Application Reference: 2026/0162

Site Address: 46 Norwood Drive, Brierley, Barnsley, S72 9EG

Introduction: This application seeks planning permission for the raising of the roof to create habitable loft area, rear facing dormers and front velux windows to roof of dwelling

Drawing Title **PROPOSED ELEVATIONS**

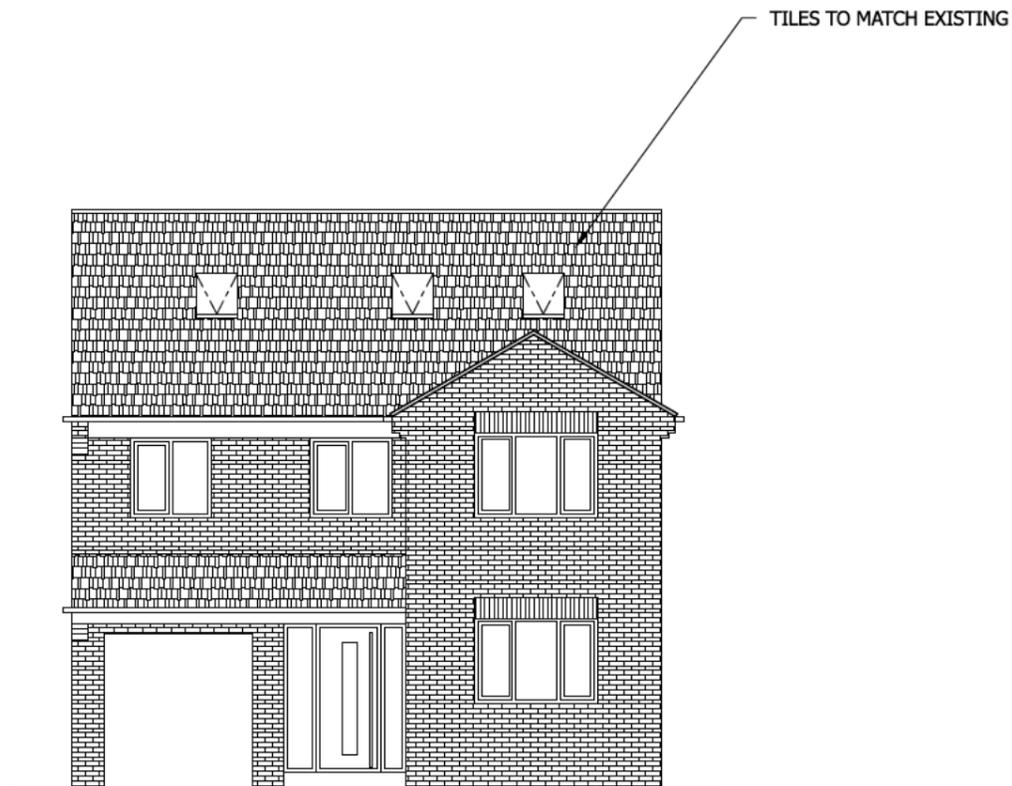
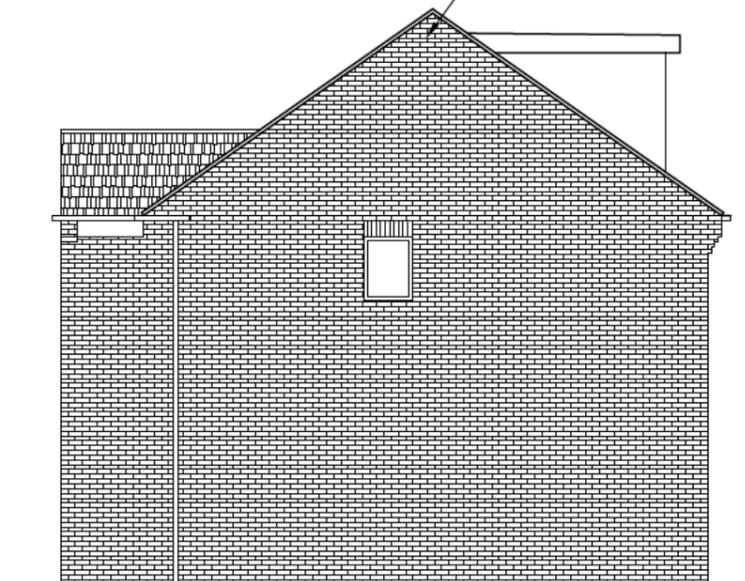
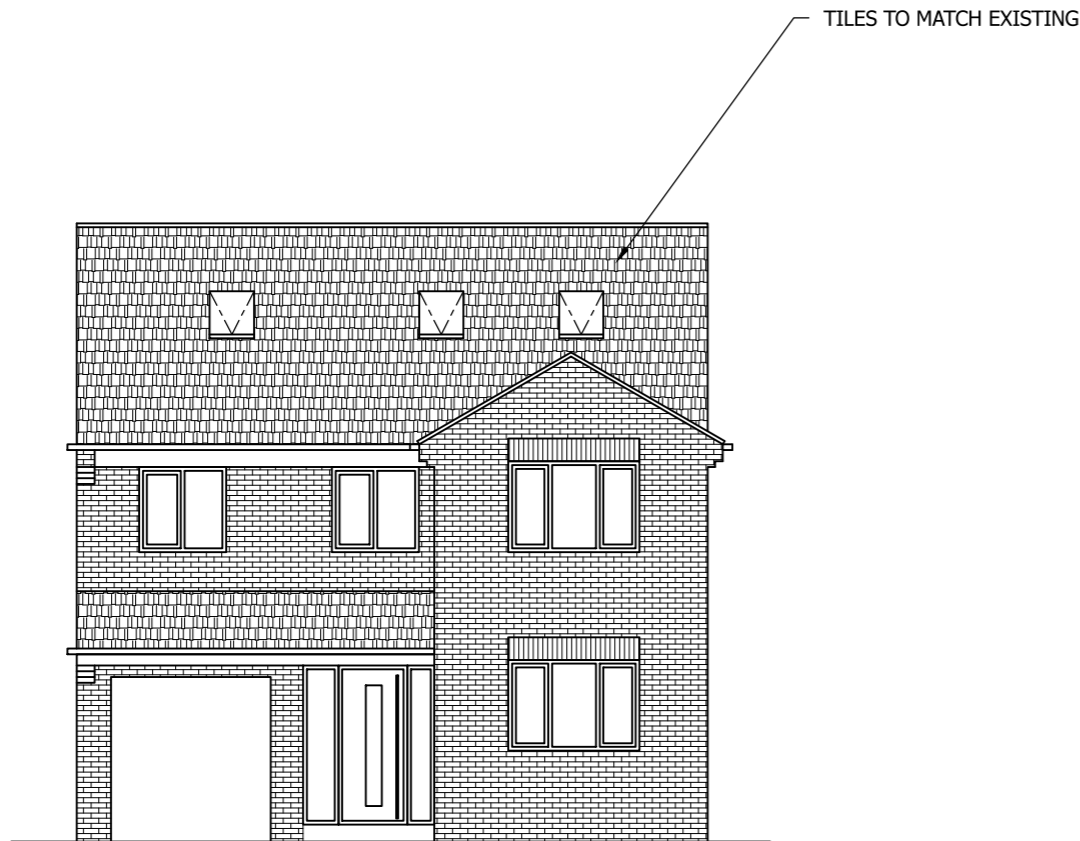
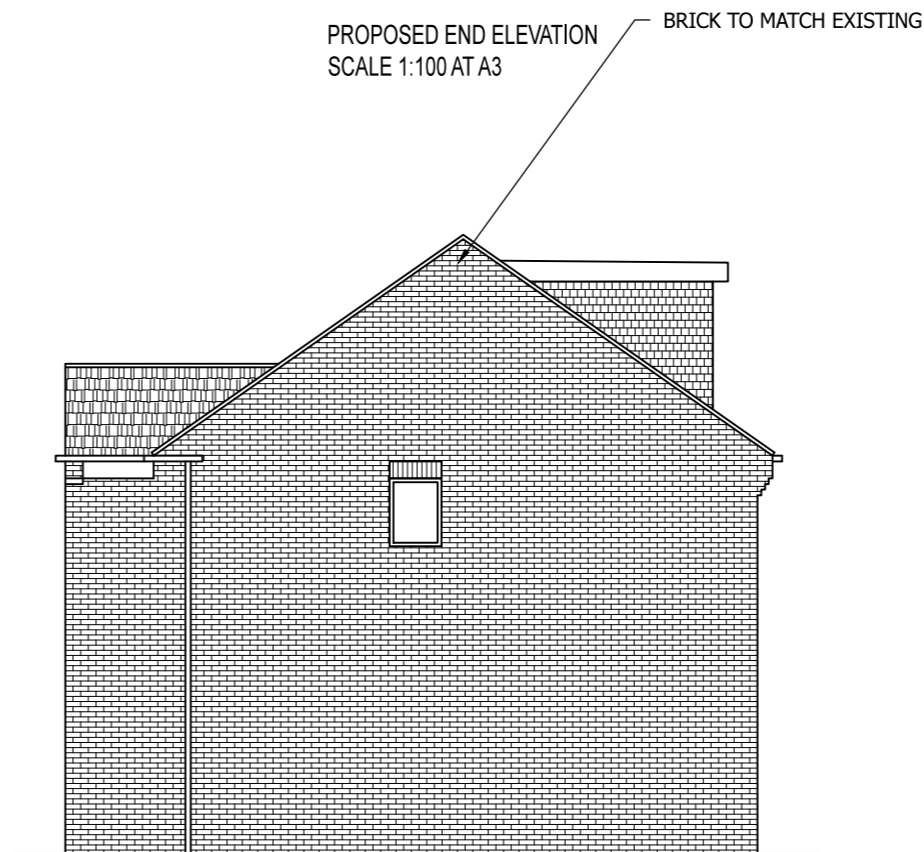
In terms of the three dormer windows to the rear, the SPD: House Extensions sets out the design principles for dormer roof extensions. So as not to dominate existing roof lines and retain the original form of the host property, dormer windows should be set within the roof plane following the guidelines set out within the policy. Whilst pitched roof dormers are recommended within the SPD, the dormers are located on the rear roof slope, so will not be visible from the main street scene and would not be overly dominant when viewed from the rear. In addition, the three dormers are set above existing windows and are more vertically proportioned, which is better visually than the use of one large dormer across the roof plane.

The original proposal included white dormers which was deemed unacceptable and contrary to policy. The scheme has been amended to reflect the principles within SPD: House Extensions, by using matching roof tiles to the front and cheeks of the dormer so that they will blend in well with the existing roof. The amended proposal is now acceptable in terms of the visual impact.

Change in materials used for the rear dormer windows to tile to match the existing dwelling

PROPOSED FRONT STREET SCENE
SCALE 1:100 AT A3

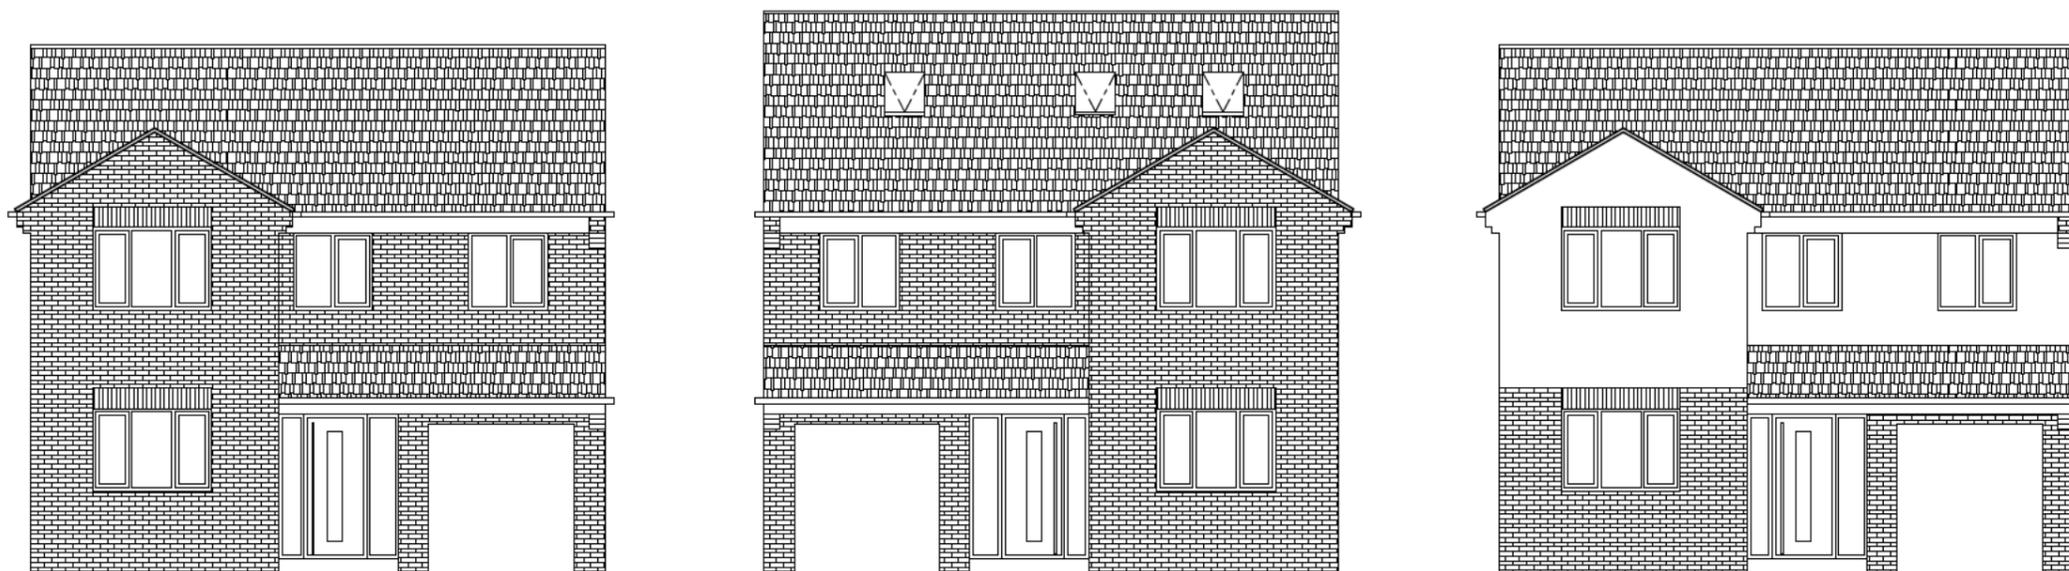
The proposal involves raising the roof of the dwelling by 0.4m in height to allow for a loft conversion, with three flat roof dormers to the rear and rooflights to the front roof slope. The agent has submitted a street scene drawing in support of the application.

The host property is a two storey detached dwelling within a street scene of properties with a similar height. Due to the small scale change to the height of the roof, the proposal is not expected to appear out of character within this setting and will rise only minimally above the neighbouring properties.
